Development Control
Ribble Valley Borough Council

App no: 24.0286

Address: 8 Walmsley Brow Billington BB7 9TT

Proposal: Proposed conversion and extension of existing bungalow into two two-storey, semi-detached dwellings, and construction of one new detached, two-storey dwelling.

PROPOSED SITE SECTIONS

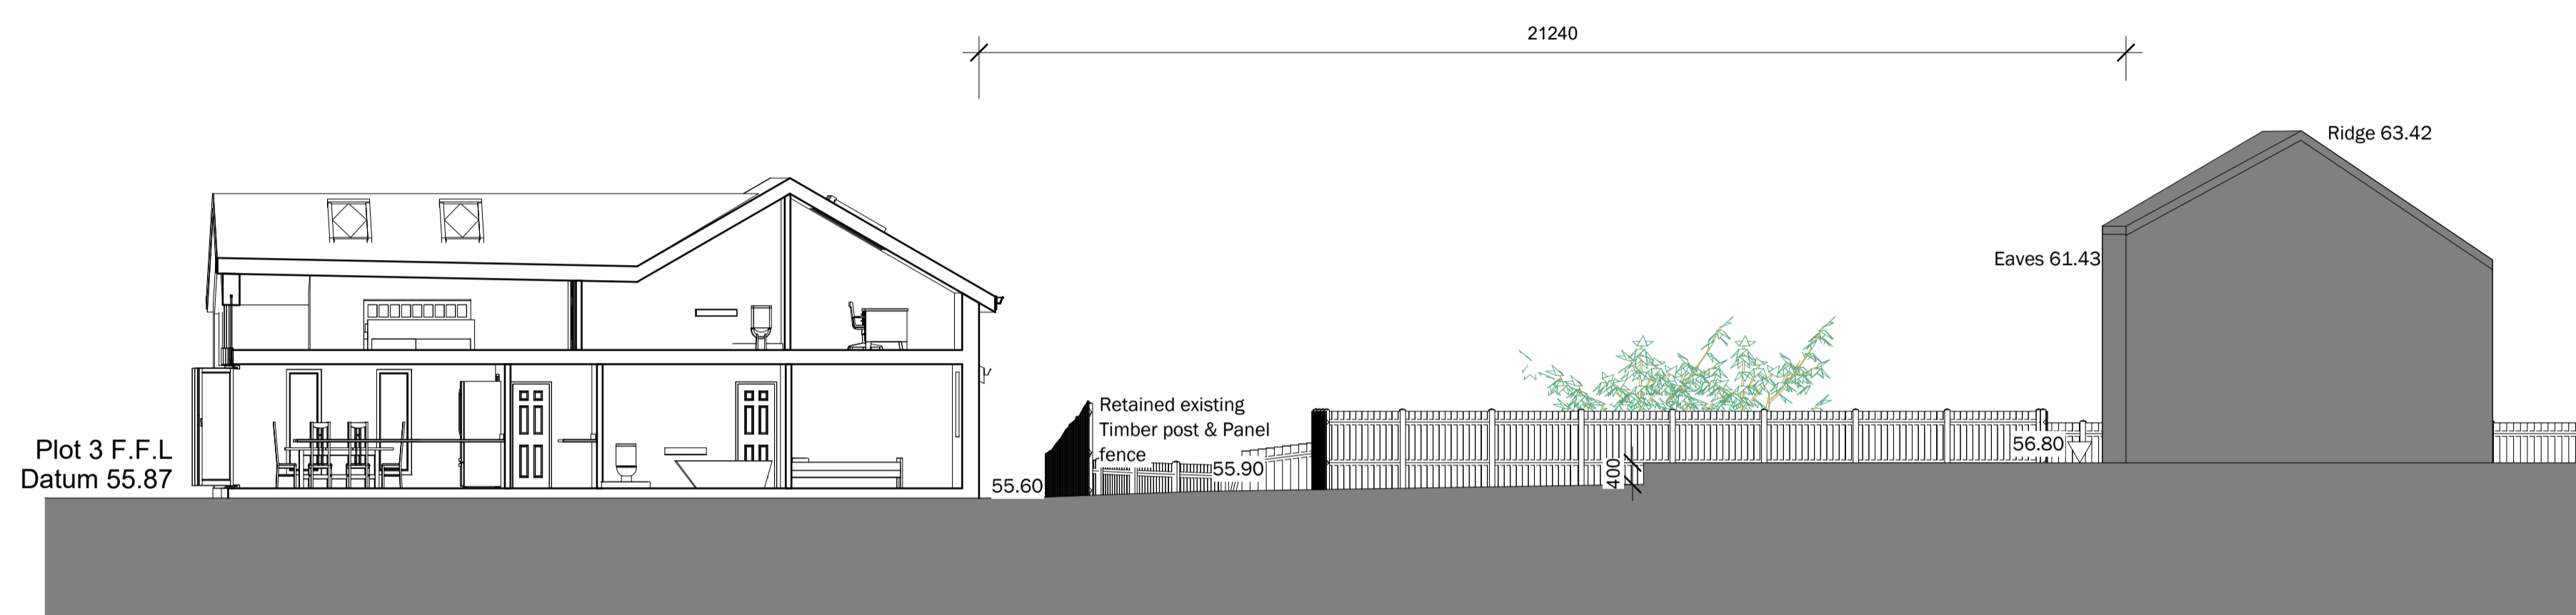
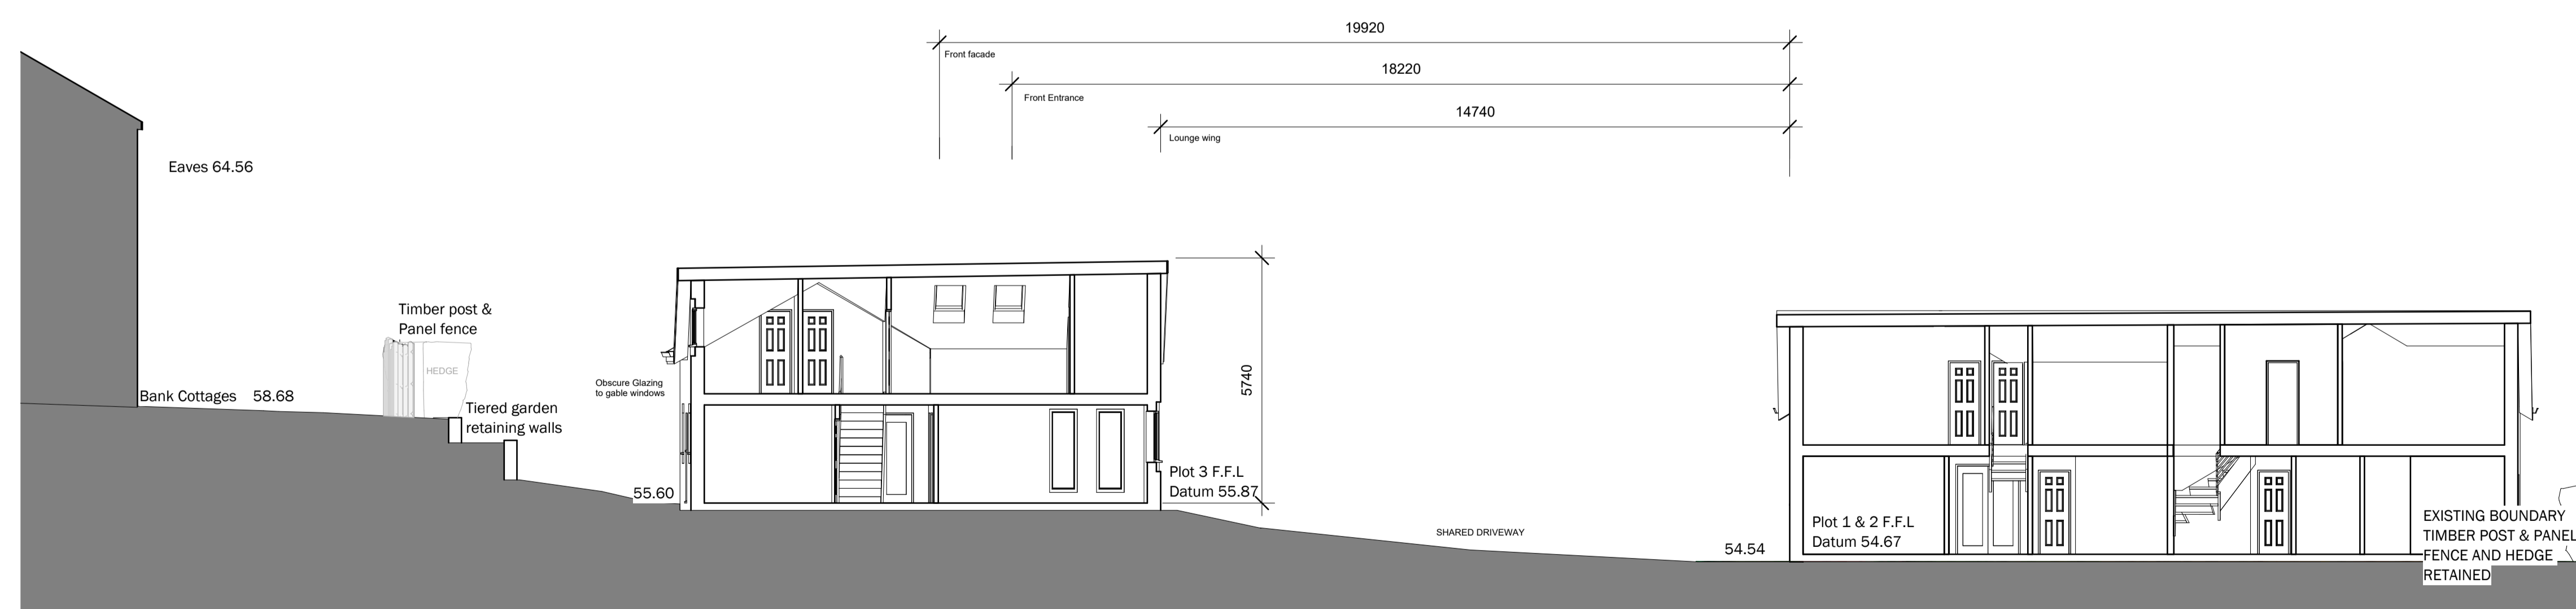
The proposed site plan includes a note adjacent to the road serving Bank Cottages that '*ground to be retained from bank cottages with tiered planting area*'. The land within the applicant's ownership appears to provide support to some extent (unknown) to the private road. We would request that any subsequent changes that

are required or are introduced into the scheme at a later date that result in changes to the ground level which may interfere with the stability of the road should be designed by a qualified structural/geotechnical engineer to ensure that the stability is maintained.

1. The parking and turning areas shall be constructed in accordance with the approved plans prior to the first occupation of any dwelling. Reason: To provide adequate car parking and turning for highway safety.
2. The secure, covered cycle stores shall be provided prior to the first occupation of any dwelling. Reason: To support sustainable travel.
3. Any changes to the ground level adjacent to the road serving Bank Cottages shall be designed by a qualified structural/geotechnical engineer and any works shall be carried out in accordance with those plans. Reason: To ensure the stability of the road is maintained.
